An
Coimisiún
Pleanála

Direction
CD-020929-25
ABP-321278-24

DRAFT WORDING FOR ORDER

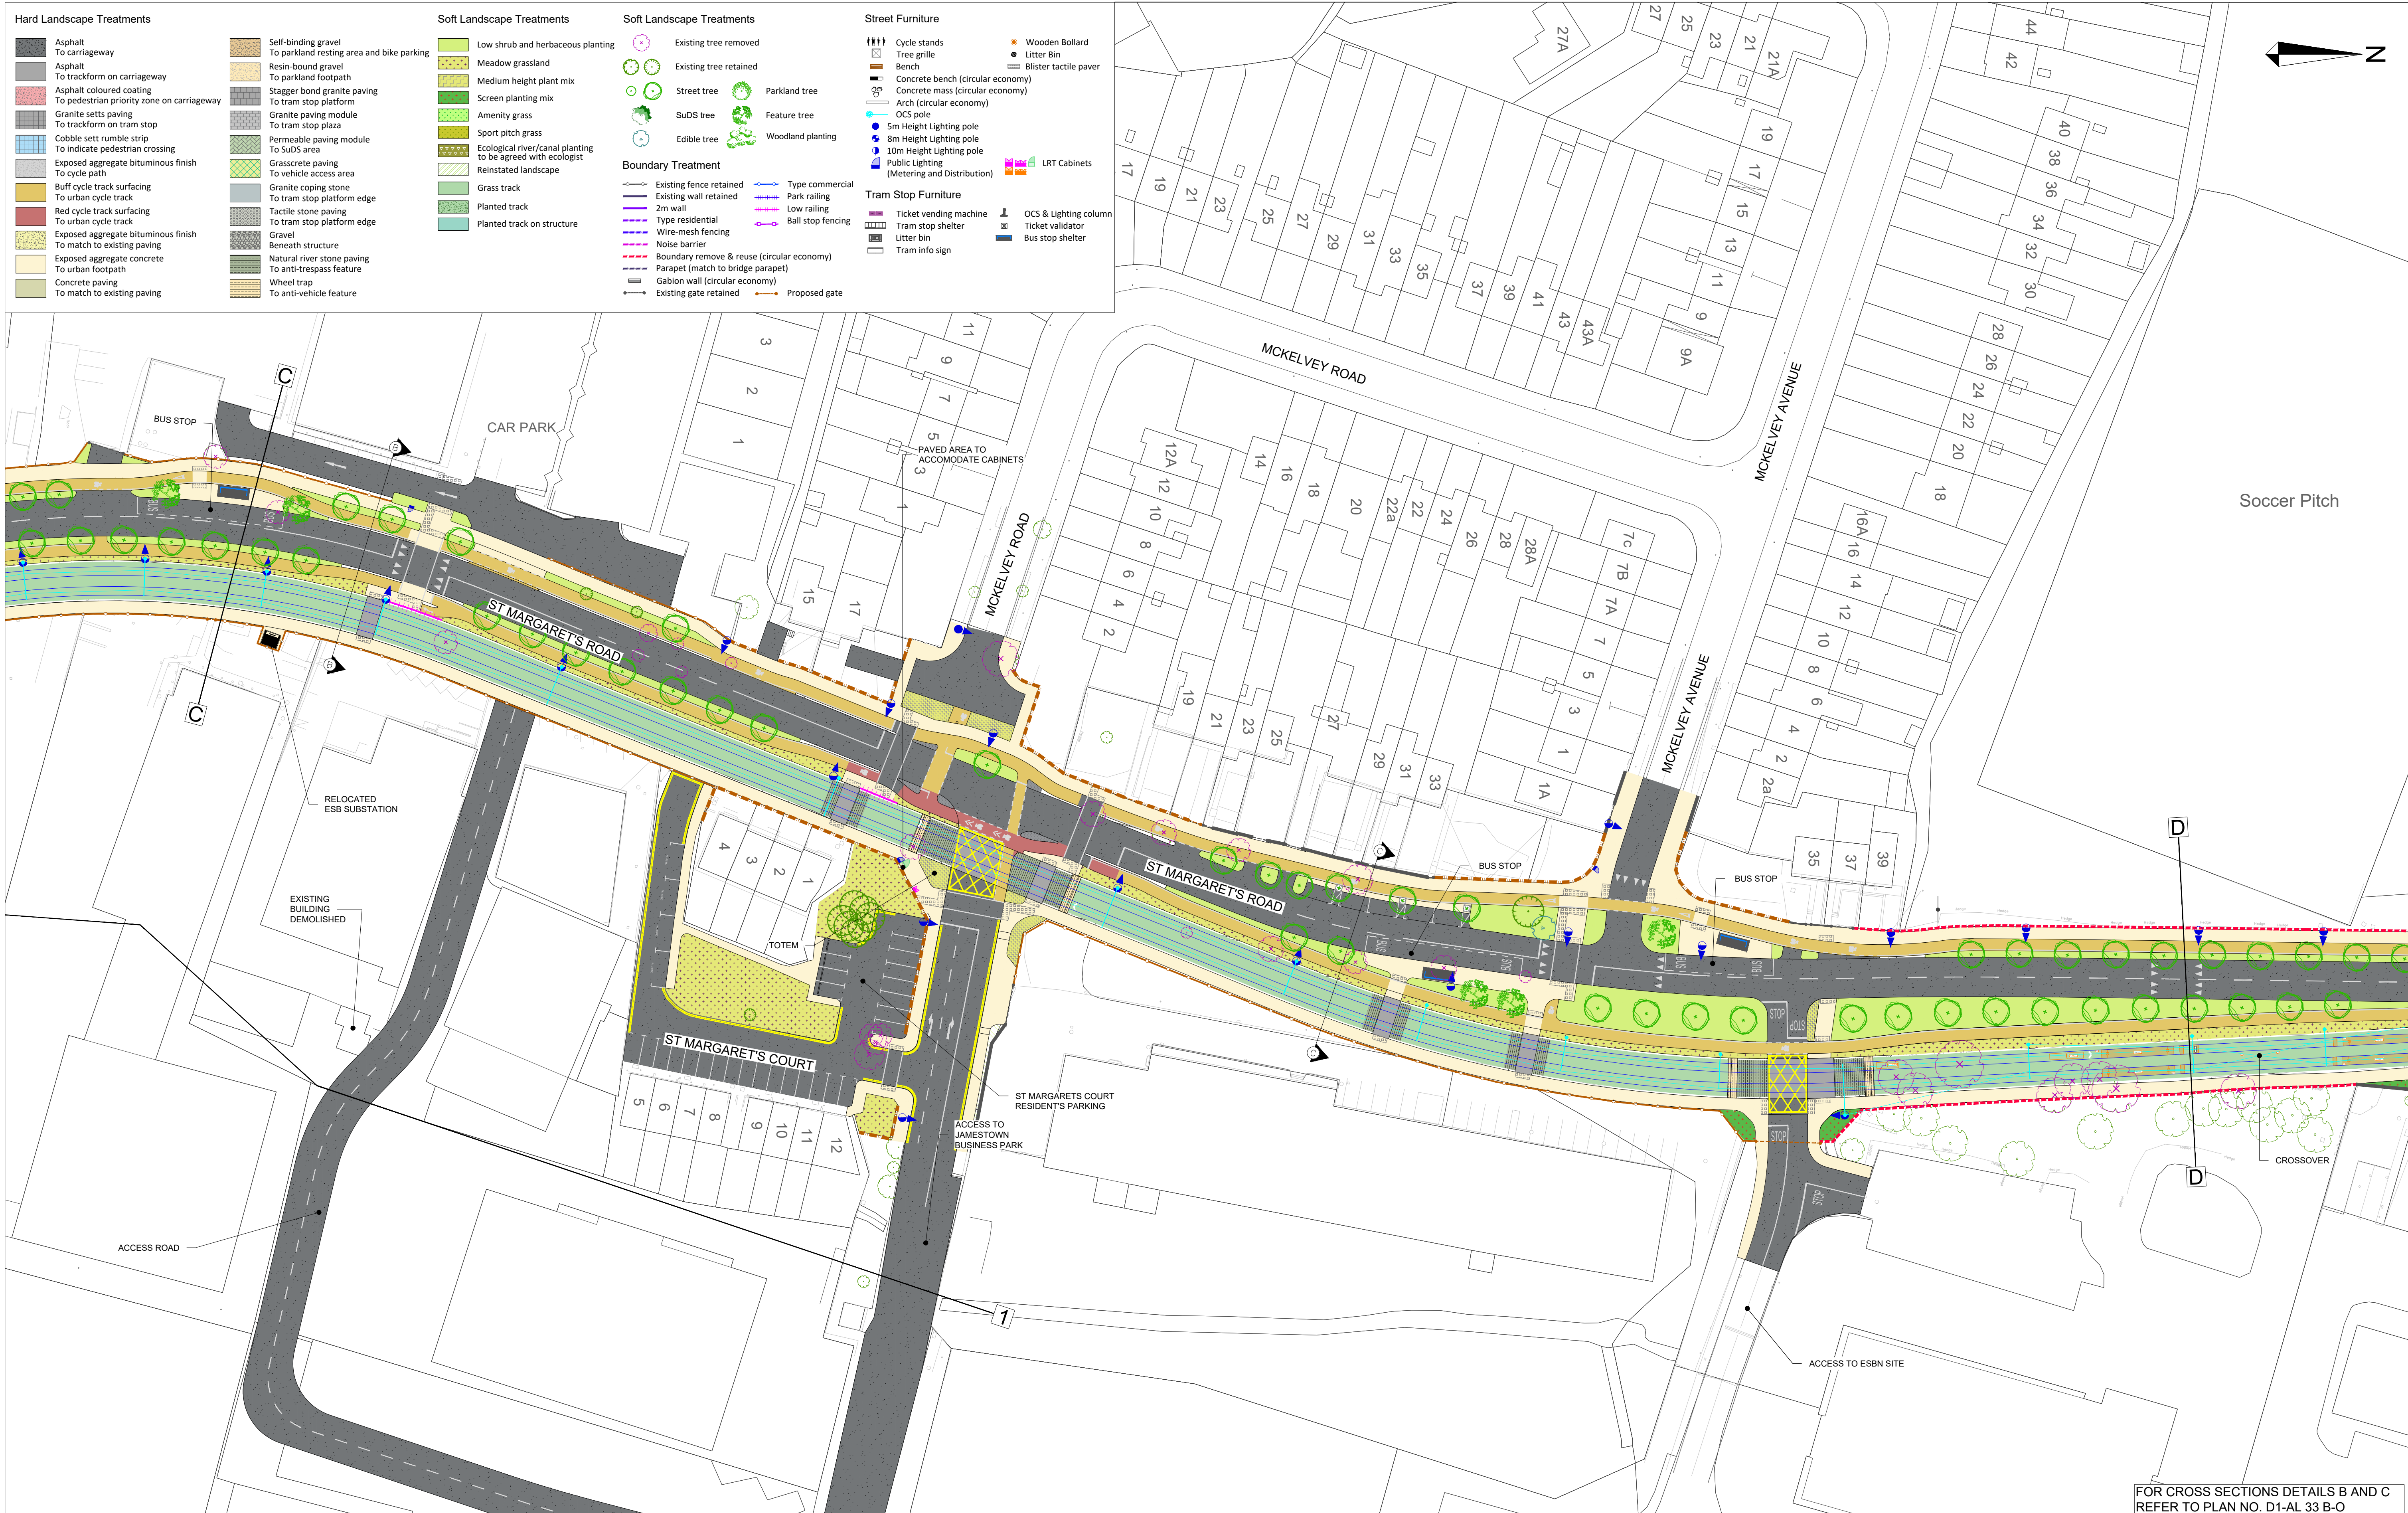
(a) The 'grasscrete paving to vehicle access area' and the bicycle shelter on the eastern side of St Margaret's Stop, as indicated on Drawing Plan Number D1-AL 33 B-C, shall be re-positioned so that the grasscrete paving runs behind the bicycle shelter hugging the adjacent residential boundary.

Revised drawings showing compliance with these requirements shall be submitted to the planning authorities for written agreement before commencement of development.
